Memorandum

Re: Re-submittal of Site Plan-DFT _ PR-2024-010784/SI-2024-01164

The following memo provides responses to DFT staff comments for the SOMOS Affordable Housing Plan, Site Plan-Administrative application heard on August 21, 2024. Staff comments are in italic followed by the Applicant responses.

DFT SITE PLAN

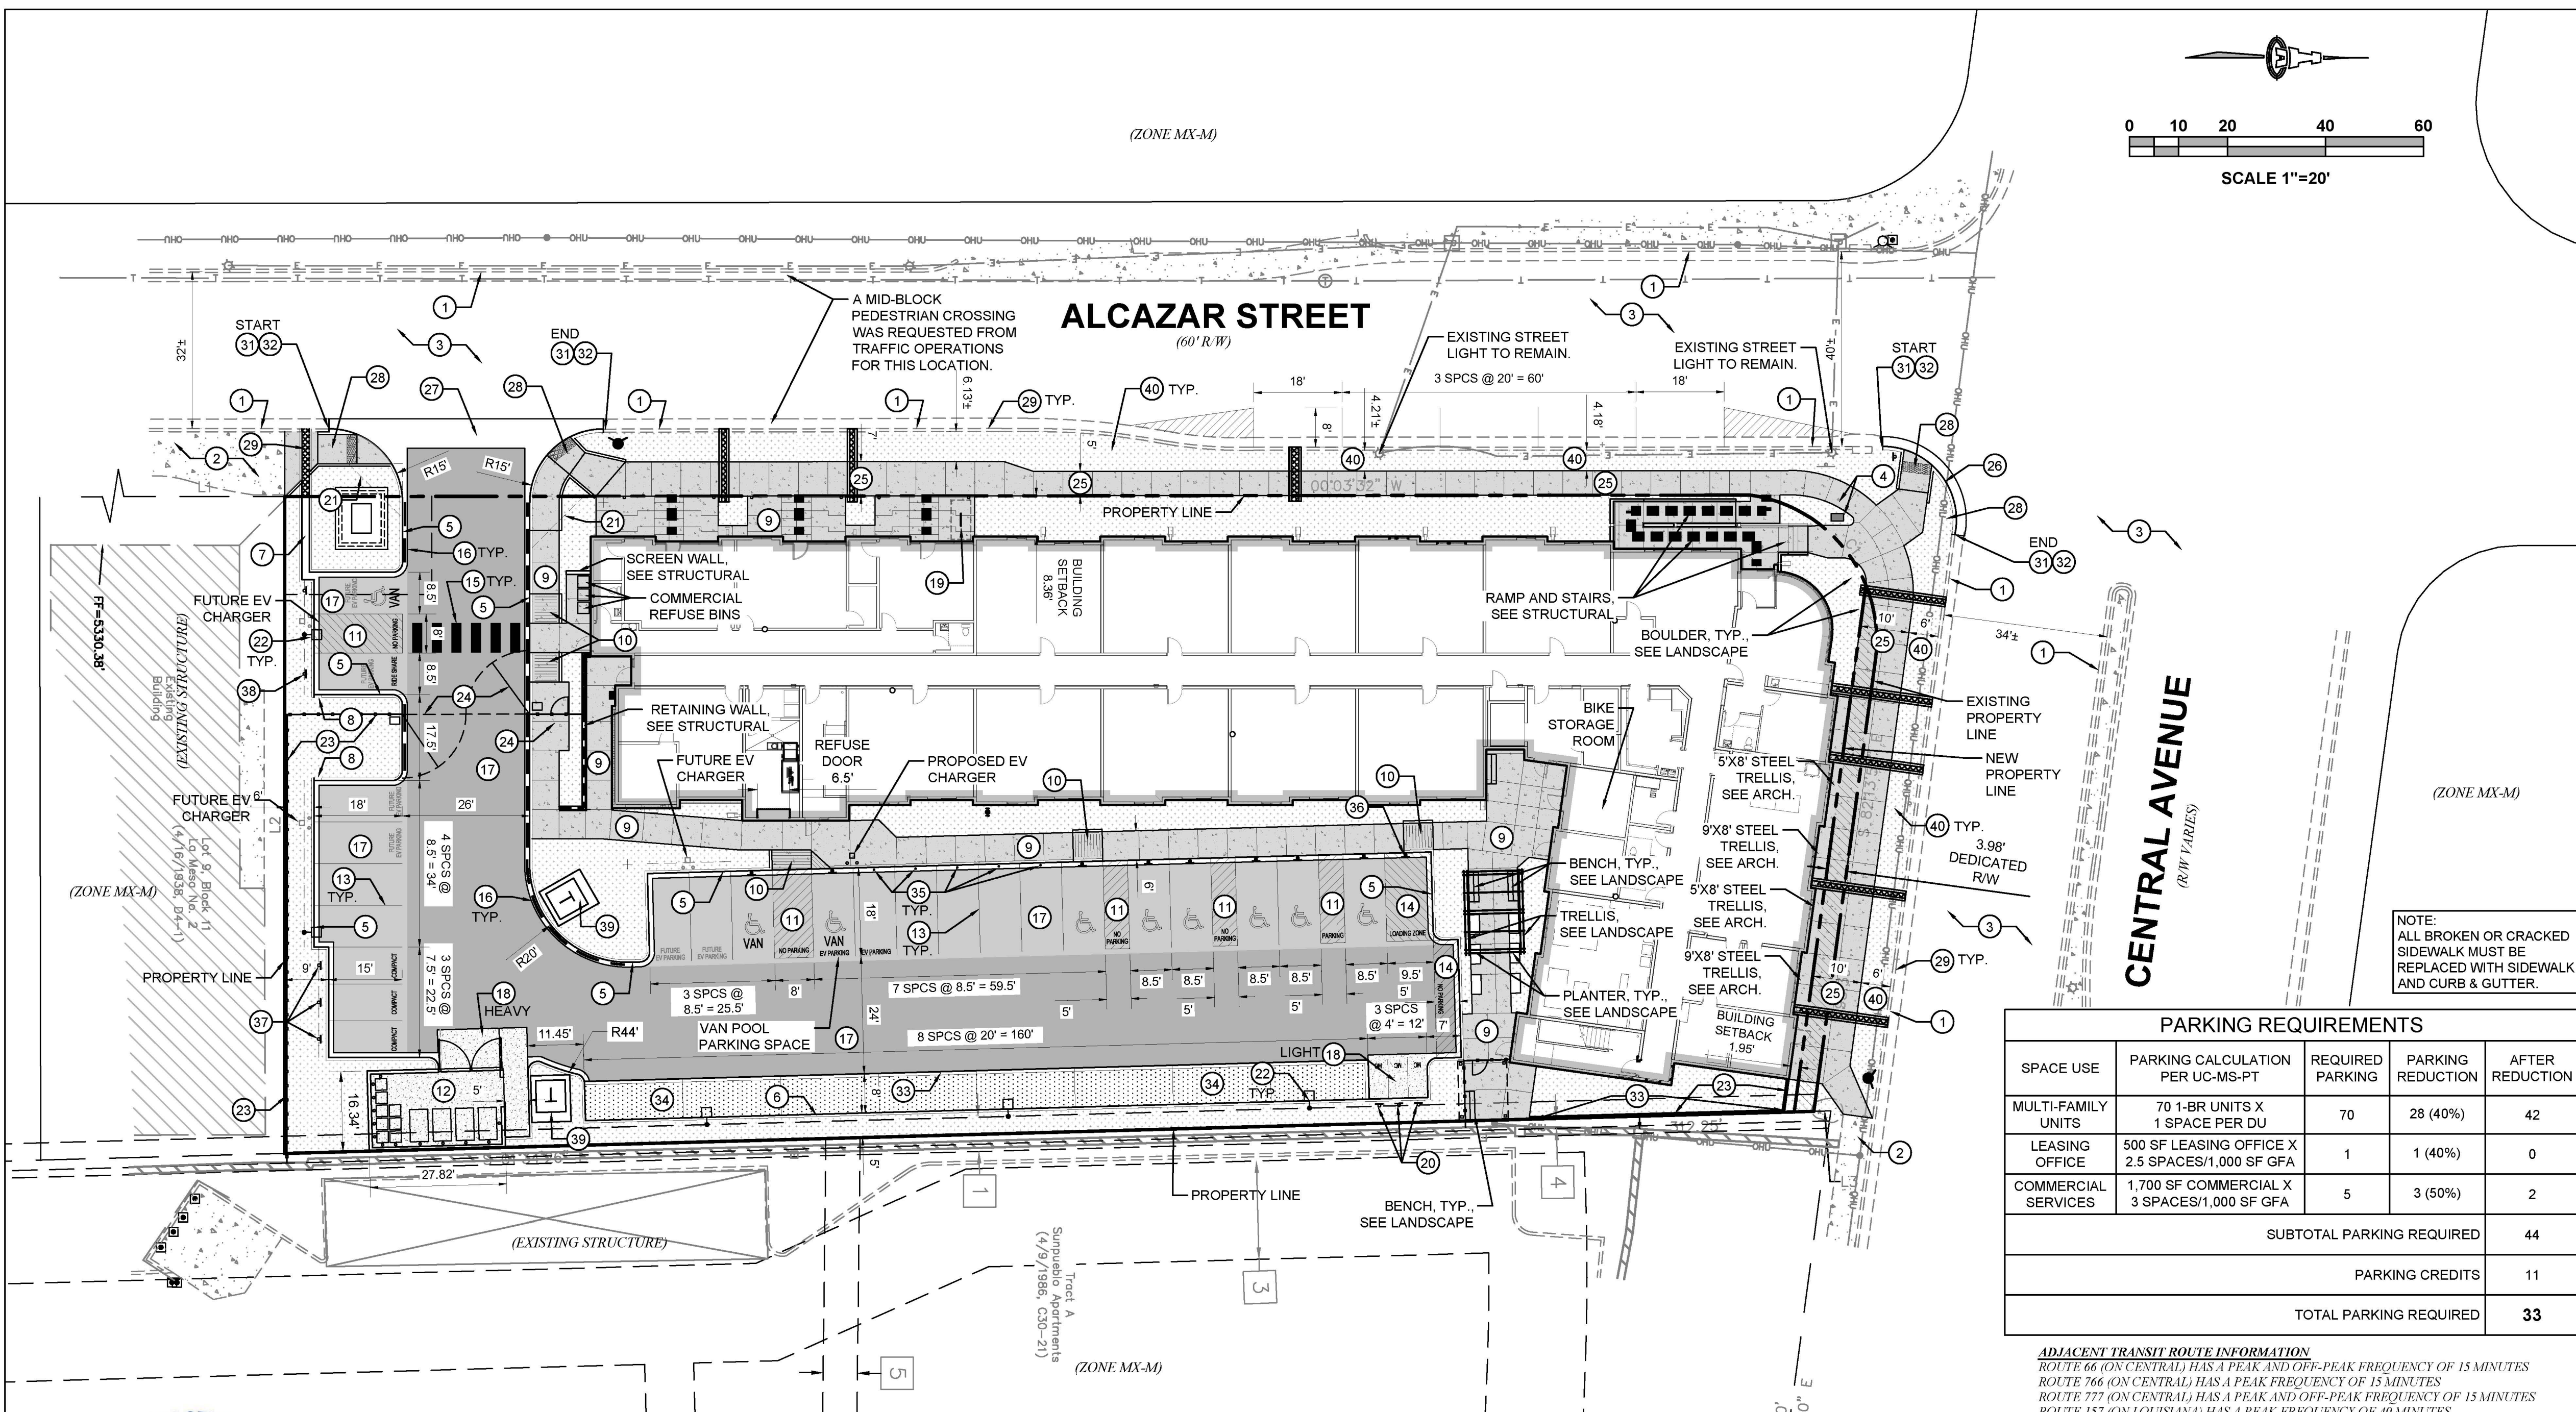
- 1. Property is zoned MX-M and Must meet all Dimensional Standards of MX-M, as per IDO 5- 1(D), Table 5-1-2. Table requires a 15 ft corner side yard setback on site plan in the UC-MS- PT areas. Site Plan shows building setback at 8.36 feet. Need to correct or obtain Variance.*

- 3. Parking calculations have several potential discrepancies, as follows:*
 - a. Parking shown for "commercial space" is calculated as 1.75/1000 x 1700 sq ft. Clarify what use is being cited for this parking calculation (ie: restaurant, retail, commercial service). Commercial services requires 3 spaces/1000.*

- b. *Parking Reduction of 50% cited as a Premium Transit Reduction, as per 5-5(C)(5)(a), is inaccurate. This section does not apply, nor does it cite a 50% potential credit. You may want to explore reductions for Proximity to transit, as per IDO 5-5(C)(5)(c).*

- e. *Shared Vehicle Program credits: please show note with details for planned use of the 4 proposed spaces as "the exclusive use of an existing car-sharing program" to be utilized.*

*Per 5-6(C)(10)(e), all screening and vegetation surrounding ground-mounted transformers and utility pads must allow 10 feet of clearance for access and to ensure the safety of the work crews and public during maintenance and repair. **Please confirm compliance with this code. Please confirm the location of this transformer.***

Applicant Response: As explained at the 8/21 DFT meeting, Table 5-1-2 requires a minimum side setback of 0 feet and a **maximum** setback of 15 feet on street sides of corner lots within UC-MS-PT areas. Therefore, the 8.36-foot side setback is compliant with the IDO dimensional standards.

Applicant Response: The Site Plan has been revised to state that the "Commercial space may be commercial service, commercial retail, or a combination of both. Therefore, the parking calculation used below is based on commercial services, which requires more parking than commercial retail." The parking calculation shows 1,700 SF commercial x **3 spaces/1,000 SF** GFA.

Applicant Response: The reference to the IDO section has been revised to IDO 5-5(C)(5)(d), which allows for a **"50% reduction"** if the proposed development is located within a **PT area.**"

Applicant Response: A note has been added to the parking calculations. A car-sharing program will be implemented as part of the development of this project.

Applicant Response: Compliant, two transformers are shown on the Site Plan (see Keyed Note #39). Access to the transformers is from the drive aisle.

LANDSCAPE
PLAN

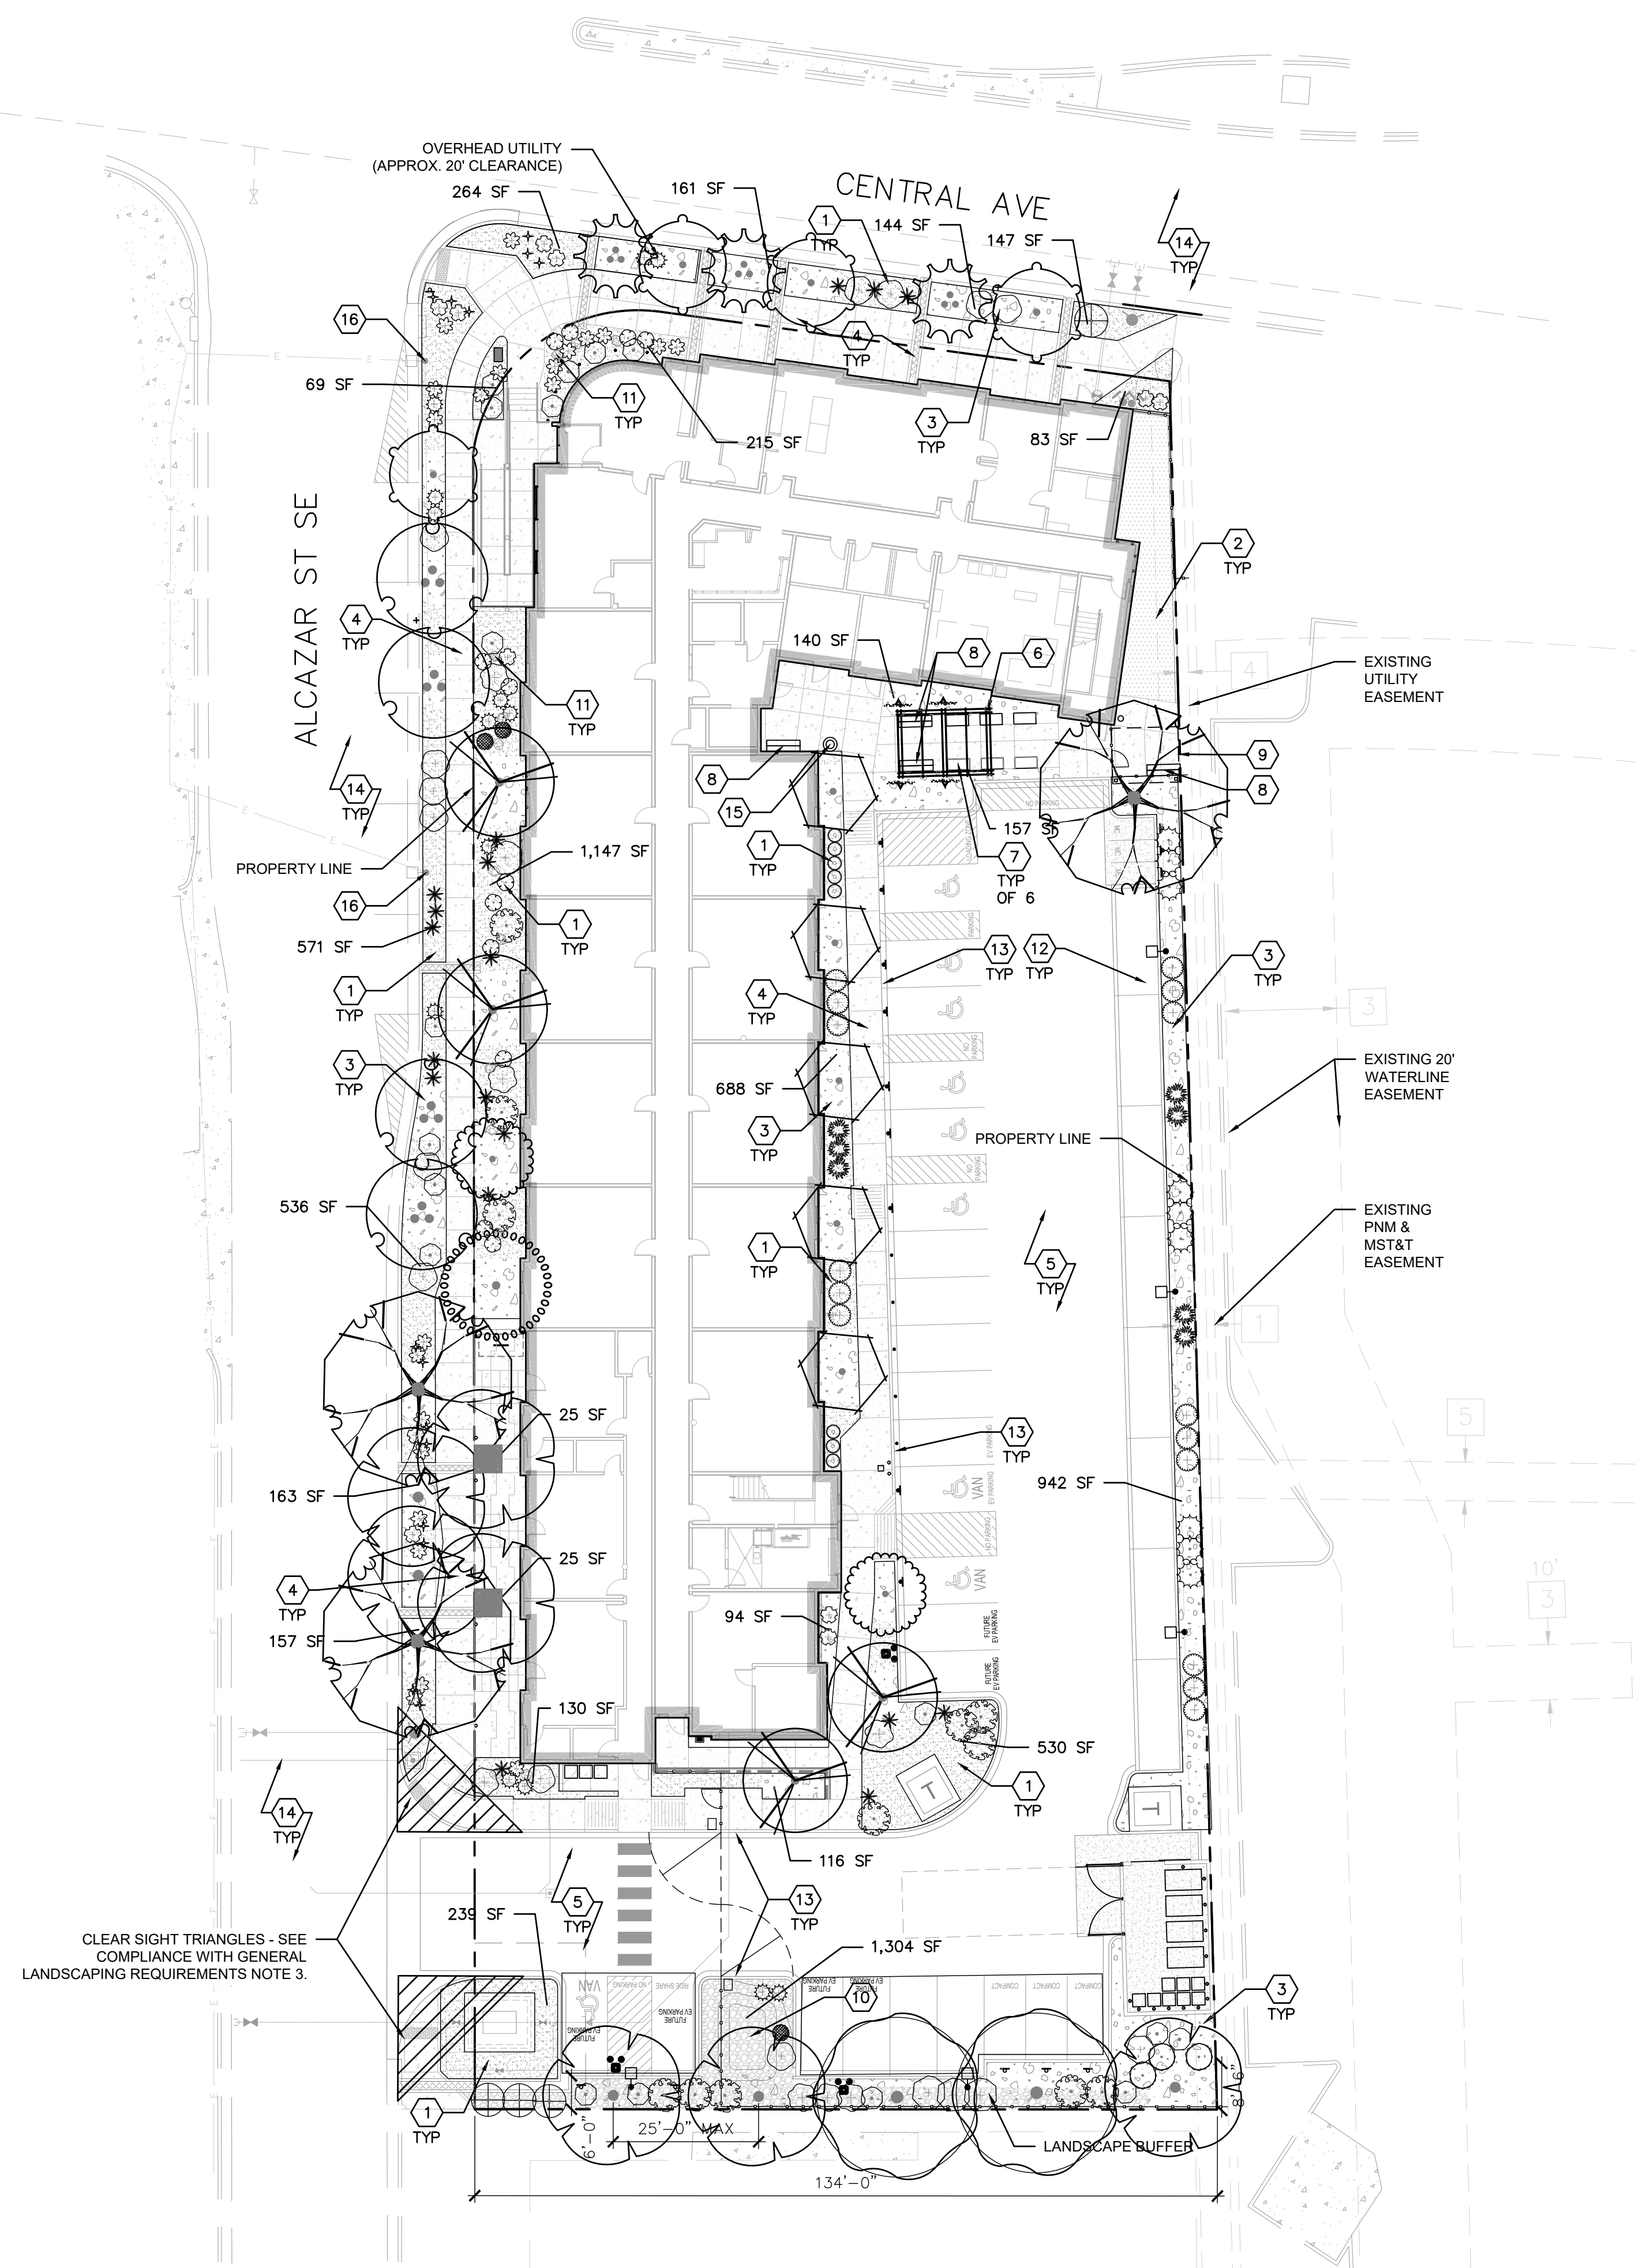
In DT-UC-MS-PT areas, this use shall provide somewhere on the lot at least 1 tree per ground floor dwelling unit, in addition to meeting all applicable standards in Section 14- 16-5-6 (Landscaping, Buffering, and Screening). Calculations for required trees must be provided.

Per 5-6(C)(5)(c), the use of gravel or crusher fines as ground cover is limited to 50 percent in DT-UC-MS areas. *Please add proper calculations to demonstrate compliance with this code. Organic mulch around trees will count towards this item.*

5-6(C)(5)(e) Organic mulch is required as ground cover under trees, not including street trees, within a 5-foot radius around the tree trunk, but not directly against the trunk. In these areas, weed barrier fabric is prohibited. (See figure below.) *Around street trees provide the organic mulch at a 5' radius as much as the space allows.*

*Per 5-6(C)(10)(d), if overhead distribution electric lines are present and large trees cannot be planted due to potential interferences with the electric lines, one ornamental tree with a mature height of 12 feet shall be planted per 20 feet of street frontage. New trees planted near electric transmission lines shall be no taller than 25 feet in height at maturity to avoid conflicts with existing electric facilities. **Consider alternating the trees in this area to avoid loss of all trees due to potential future disease. Pink Pom Poms redbud, Paul's Scarlet Hawthorne, and Goldenrain tree are suggested by the City Forester for these areas.***

*Per 5-6(C)(10)(f), trees shall not be planted near existing or proposed street light poles. 15 feet of clearance is required. **Please confirm compliance with this code.***

Applicant Response: Compliant, calculations for required trees are provided on the Landscape Plan.

Applicant Response: Compliant, calculation was added to Landscape Plan.

Applicant Response: Compliant, added to Landscape Plan.

Applicant Response: Compliant. Revised Landscape Plan includes Pink Pom-Pom Redbud along Central Avenue.

Applicant Response: Compliant. Revised locations shown on Landscape Plan.
